Consultation Response from KC, Conservation & Design**2023/91257 Reap Hirst House, Reap Hirst Road, Birkby, Huddersfield, HD2 2DD****Listed Building Consent for demolition of existing conservatory, and erection of single storey extension, new rear entrance canopy, replacement windows and door and reintroduction of mullions and chimney, minor external modification and internal modifications of modern partitions****Date Responded: 16.10.2023****Responding Officer: Sue Brooks****Responding Ref:**

Proposed North Elevation - 1:50

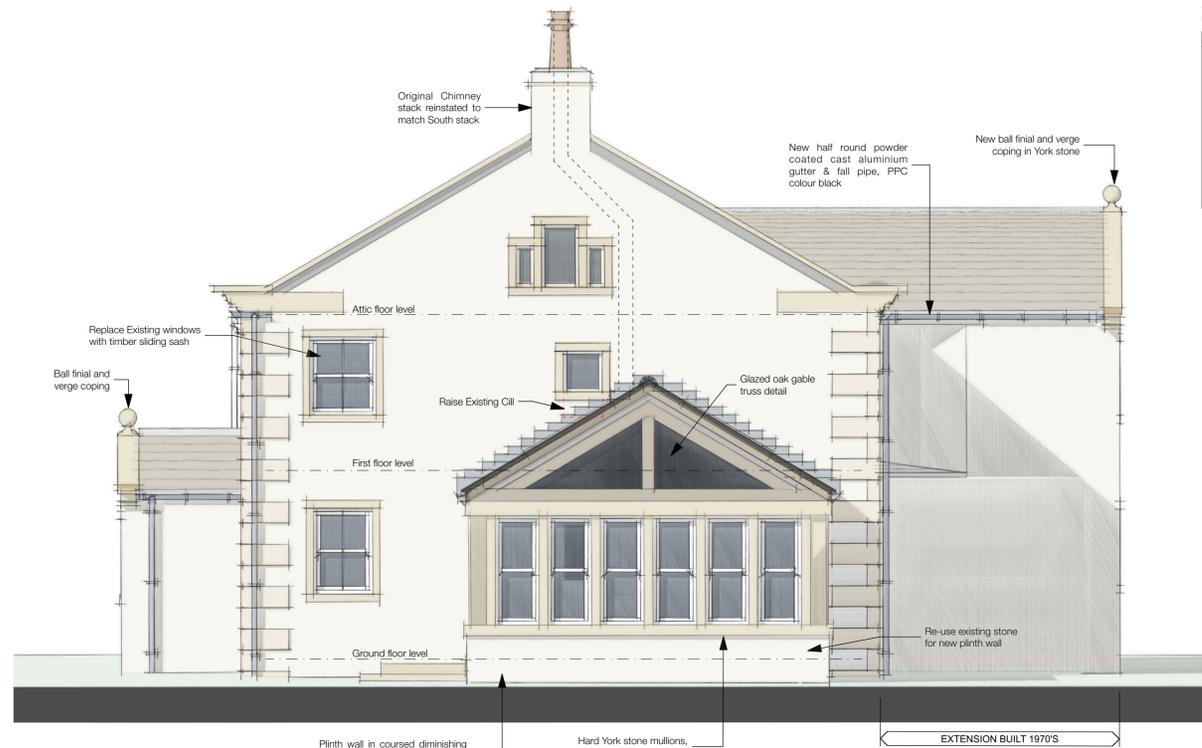
The proposed chimney stack on the north gable reinstates a missing historic feature which is shown

on the submitted archive image.

Proposed South Elevation - 1:50

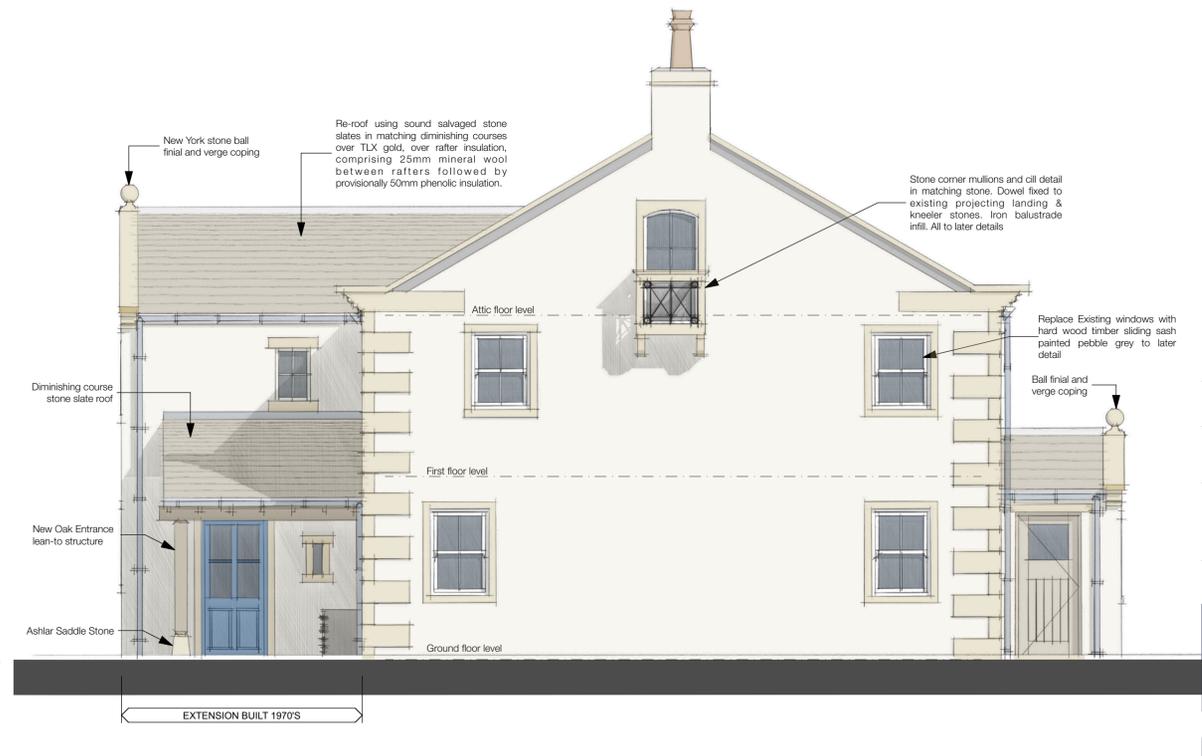
A new window is proposed on the south elevation at first floor level. The proportions and configuration of the window and surround match the others on this elevation, and the introduction of further natural light within the space outweighs the slight harm to significance.

Also on the south elevation is a large attic window with an external projecting ledge. This may have been an external door to the attic, although later rebuilding around the opening hides any evidence of the original detailing. Two archive images have been submitted within the design and access statement, one showing the opening infilled with a possible lightweight railing around the ledge, and another showing a fairly substantial projecting structure with a pitched roof and turned balustrade, extending beyond the ledge. The application proposes a small balustrade around the ledge and we consider this to be justified based on historic precedents. We would recommend that final details are submitted as a condition discharge.

- Notwithstanding the submitted plans and information, full details of the proposed balustrade fixed to the projecting attic floor ledge on the south elevation (elevation drawings at 1:20 scale and section drawings at 1:5 scale), shall be submitted to and approved in writing by the Local Planning Authority prior to this work commencing. The works shall be carried out in complete accordance with the approved details.
